Arun District CouncilDate Inspected: 9th January 2014

Planning Application Ref: not advised but Pre App Ref was PAA/10/13

Location : land around Broadlees, Dappers Lane, Angmering

Description of work: Tree pruning works along Dapper Lane and Water Lane to achieve a safe clearance above proposed new footpath link. The felling of trees throughout the site to facilitate development and access arrangements.

Proposed Site Plan

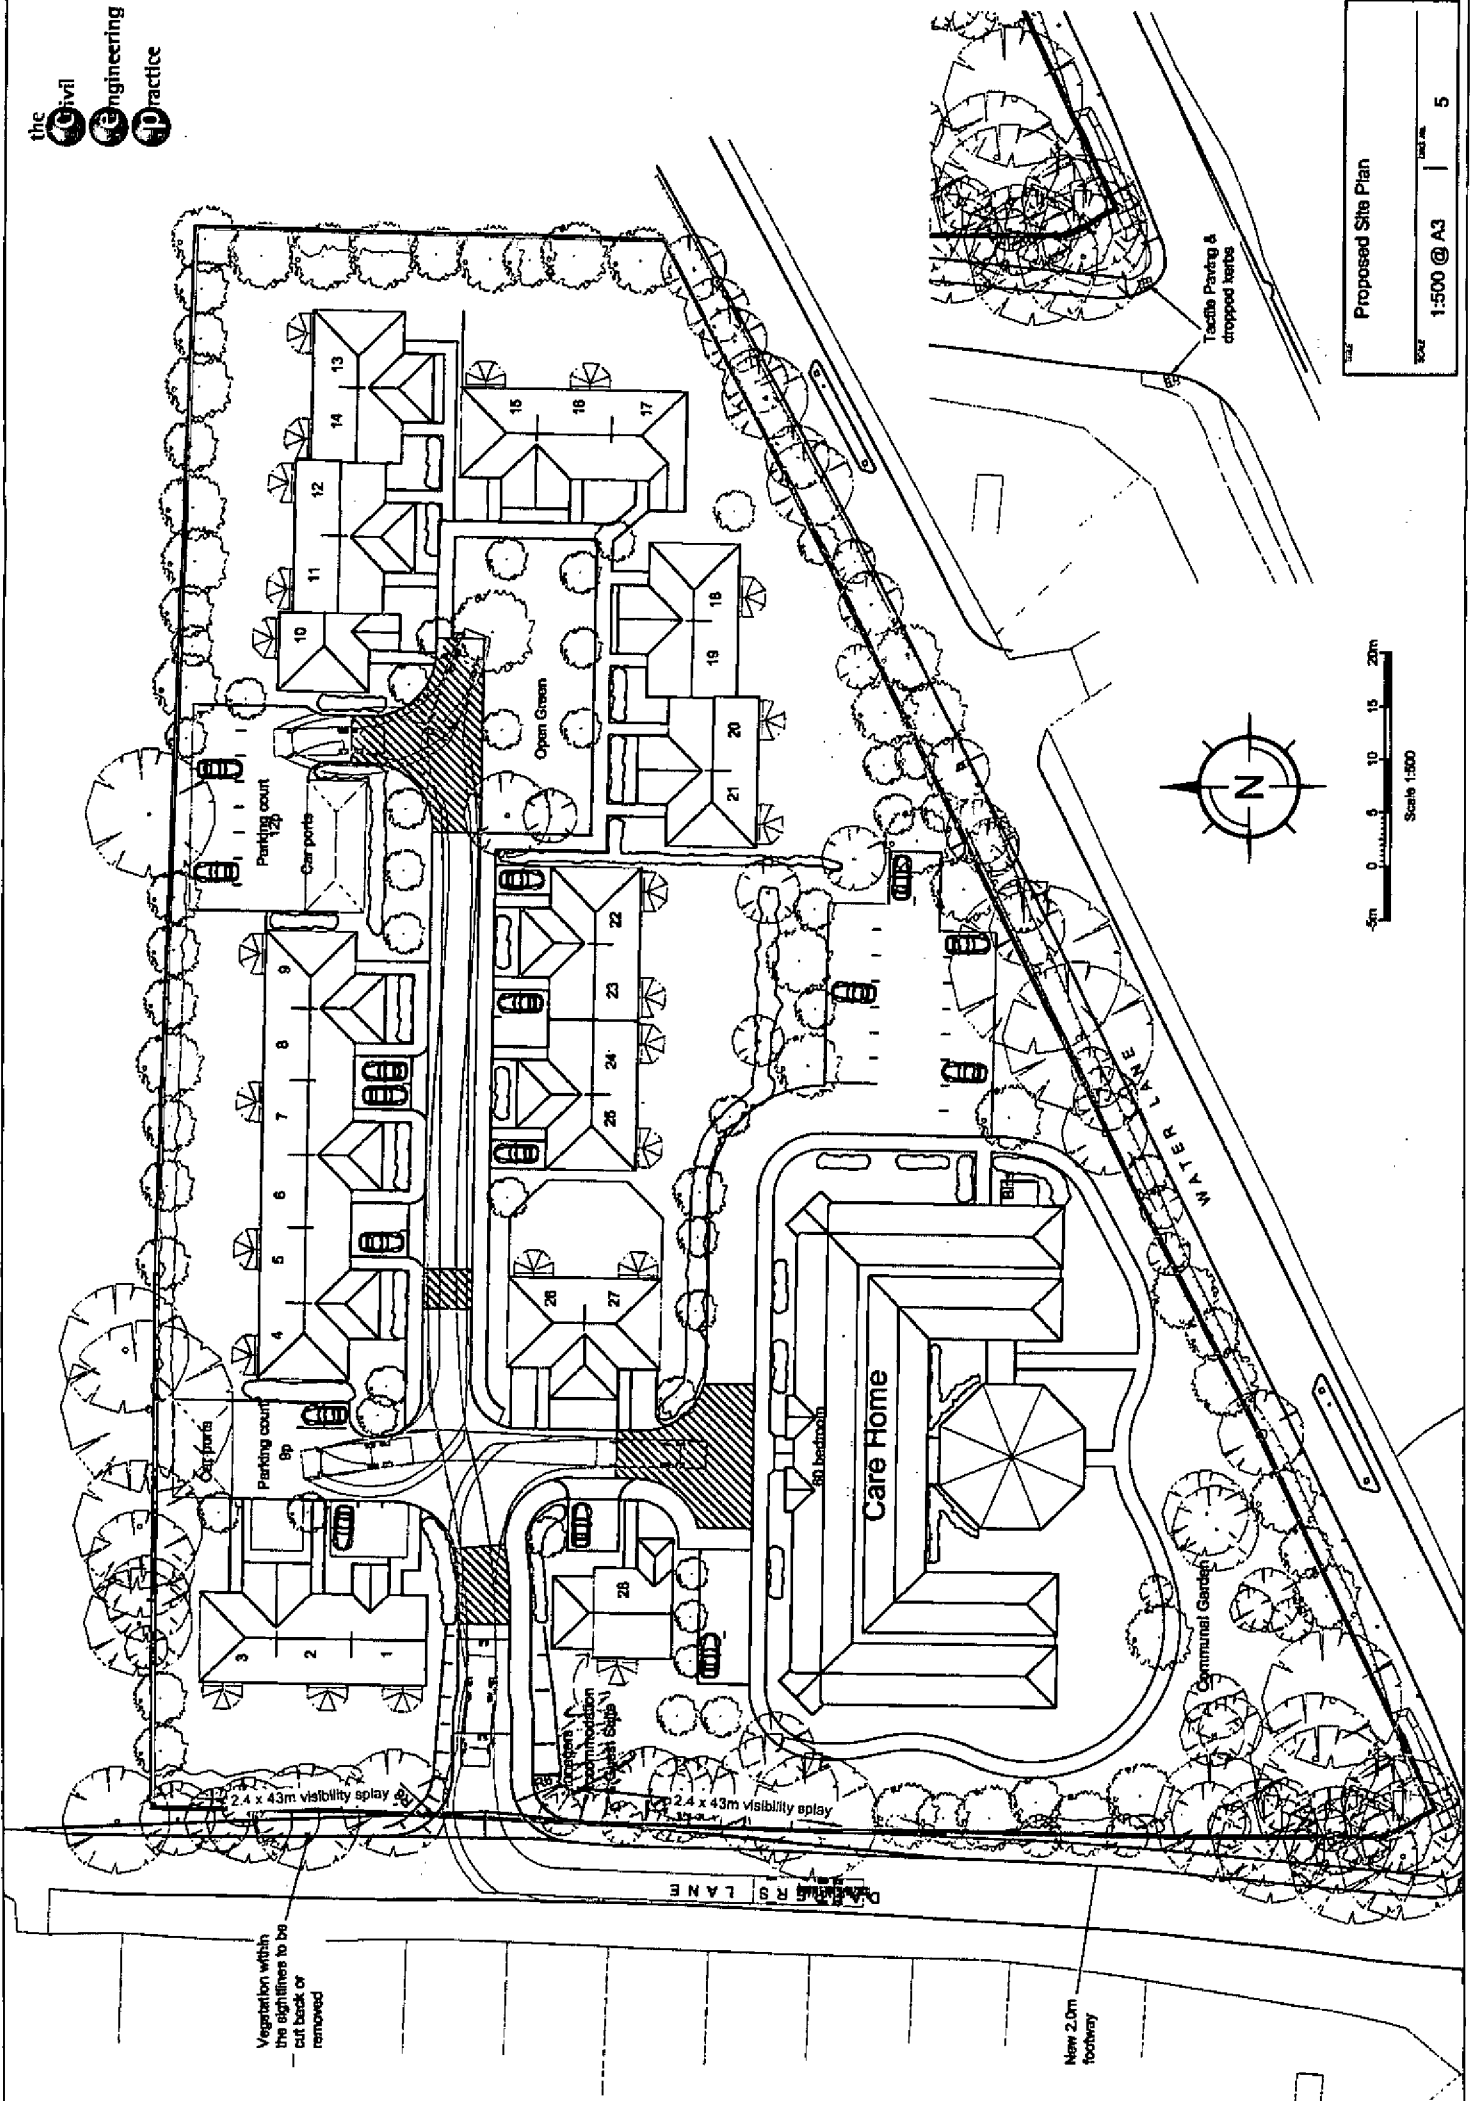
This development proposal requires the loss of an Ash tree (their T6) which is a highly visible tree of high amenity value that merits a TPO and in my opinion the development layout needs to be amended to accommodate the full RPA [550mm diameter tree = 6.6m radial protection zone] of this tree without compromises and changes in levels around it. This may involve changing the location of the access drive to allow for the visibility splays and re-routing the proposed footpath outside of the Ash trees RPA.

- I object to the removal of certain trees which would be lost to development and recommend that a Tree Preservation Order is made to protect them and several other valuable specimens on this site where development proposals threaten their safe and healthy retention.
- The trees I recommend for the TPO are shown on the attached TEMPO forms and plotted on the attached site plan.
